Ribble Valley Borough Council
Council Offices
Church Walk,
Clitheroe
Lancashire
BB7 2RA

Phone: 0300 123 6780
Email: developeras@lancashire.gov.uk
Your ref: 3/2025/0643
3/2025/0644
Our ref: 3/2025/0643/HDC/KW
3/2025/0644/HDC/KW
Date: 25 September 2025

Location: Barn 2 Writtenstone Farm Writtenstone Lane Longridge PR3 2ZN
Proposal: Planning permission for proposed conversion of Barn 2 within the curtilage of the listed Writtenstone Farmhouse, into ancillary residential accommodation. Works to include insertion/infilling of window and door openings, replacement of cement fibre roofing with slates and engineering operations to include the lowering of the ground level adjacent to the barn.
Grid Ref: 362587 437880

Planning Application
Proposed Site & Roof Plan
 DATE July 2025

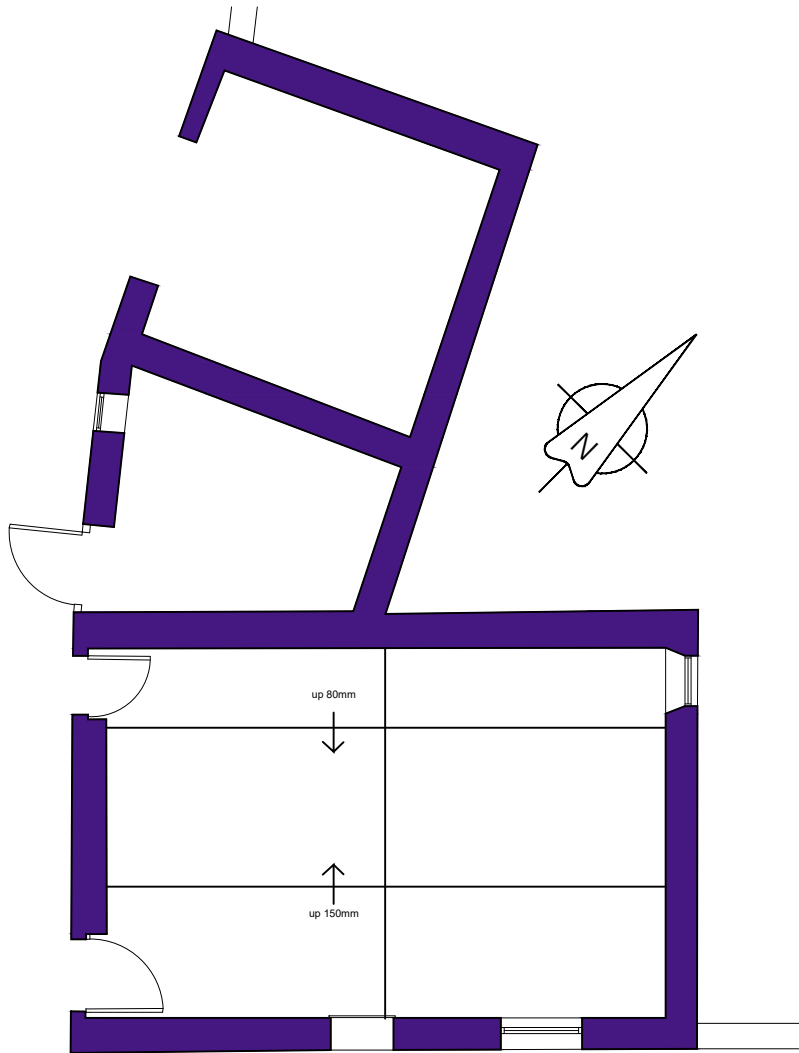
The LHA have reviewed the Proposed Site & Roof Plan and are aware that the site access will remain unaltered following the proposal. Therefore, the LHA have no further comments to make regarding the access.
